WEST SUSSEX COUNTY COUNCIL CONSULTATION

TO:	Arun District Council FAO: Maria Tomalova
FROM:	WSCC - Highways Authority
DATE:	20 August 2019
LOCATION:	Land south of garage compound & East of 12 Alfriston Close, Felpham, PO22 6QE
SUBJECT:	FP/139/19/OUT Outline application with all matters reserved for the erection of 1 No. dwelling.
DATE OF SITE VISIT:	N/A
RECOMMENDATION:	Advice
S106 CONTRIBUTION TOTAL:	N/A

FP/139/19/OUT, Land south of garage compound BLOCK PLAN 1:200 scale

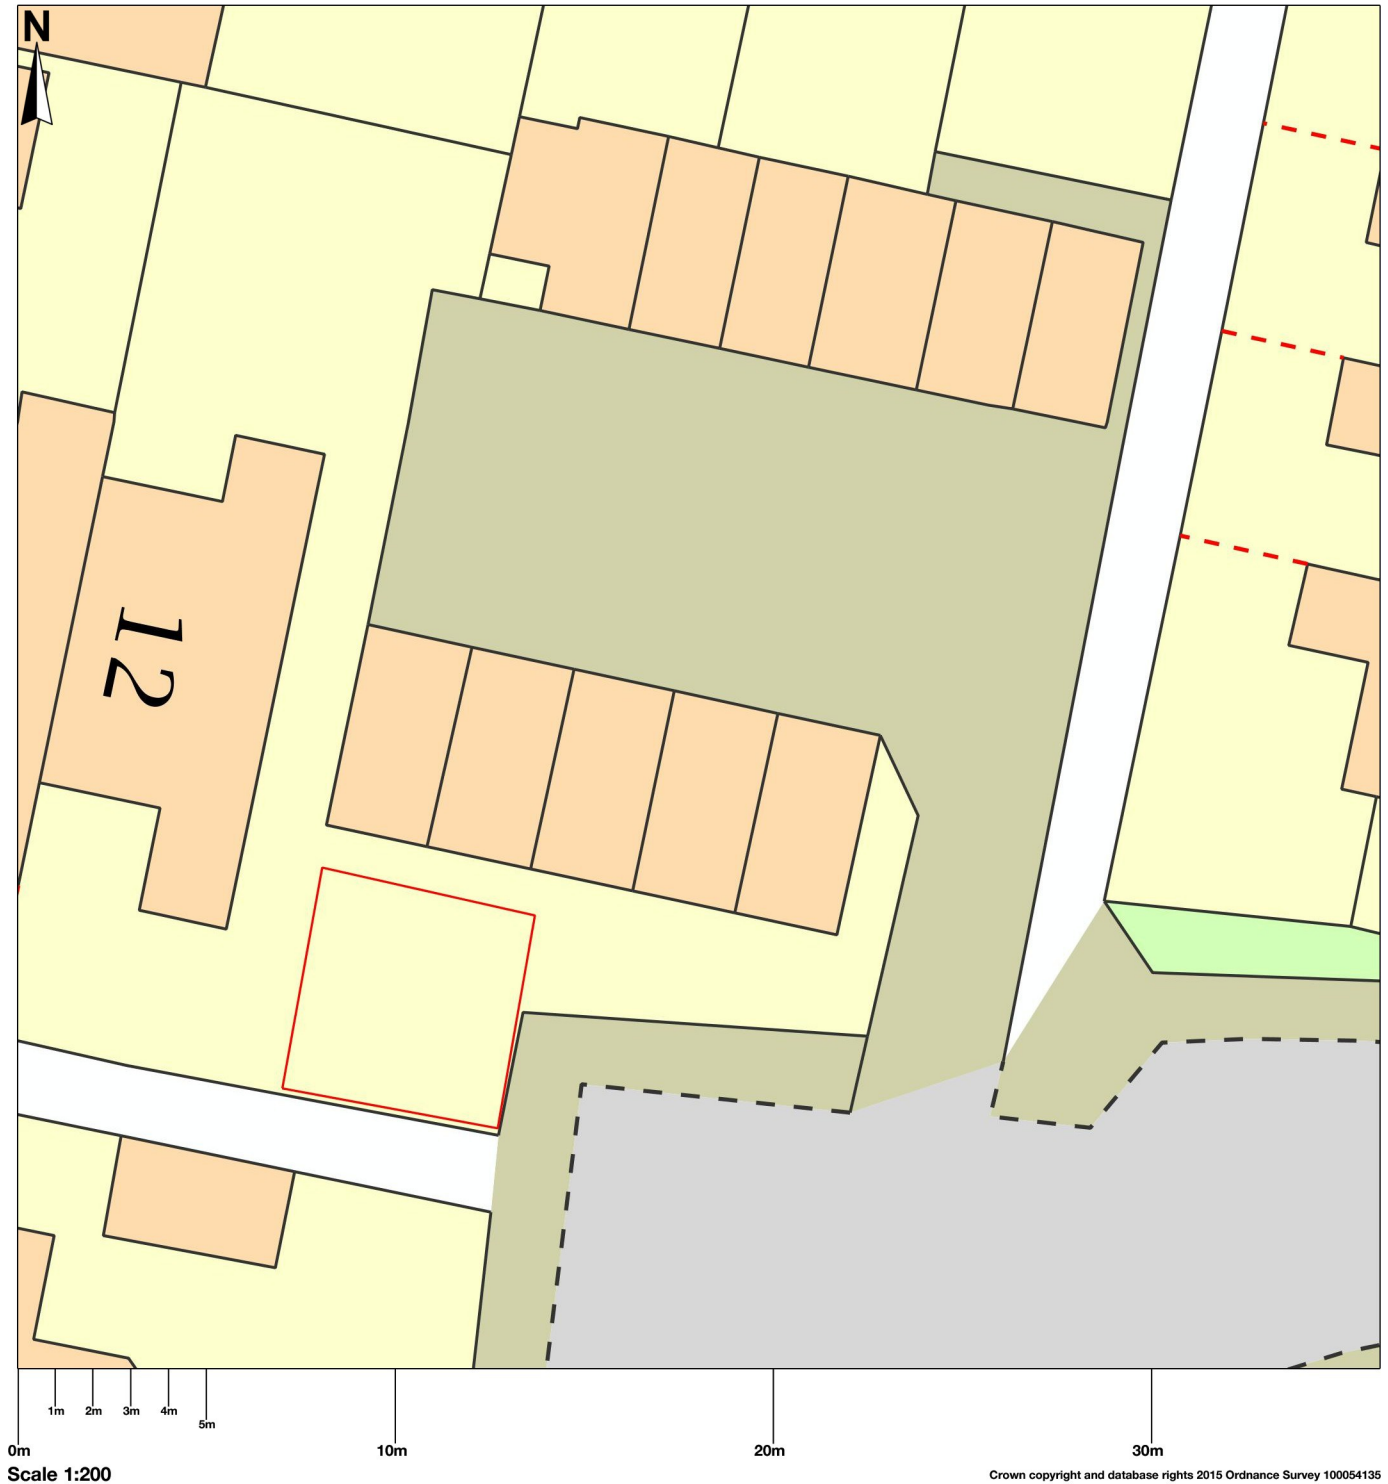
WSCC previously submitted a response dated 18th July. Additional comments were also provided dated 30th July 2019. An amended block plan has been received; consequently an updated response can be made.

Given the site is situated at the end of a cul-de-sac, visibility splays of 43 metres will not be achievable in at least one direction. However, there is good forward visibility and the road is anticipated to be low speed and lightly trafficked.

A vehicular access serving the dwelling should be 3m wide in accordance with WSCC standards for a single access. A dropped kerb would be required for a new access which would be subject to a licence. New accesses should be situated at least 1.5m away from any street furniture or street lights.

As mentioned in the further comments made by WSCC dated 30th July 2019, the WSCC Area Engineer raised concerns regarding building within publicly maintained highway. Using Local Mapping, it appears the whole site is classified as publicly maintained highway. In order for this land to be incorporated into the site, the highway rights need to be formally removed by way of a

There is also no guarantee that this process would be successful. The comments made here would not necessarily constitute the Highway Authority's formal position regarding any future stopping up. The applicant should be aware that the LHA would not wish to see any loss of footway width in this location.
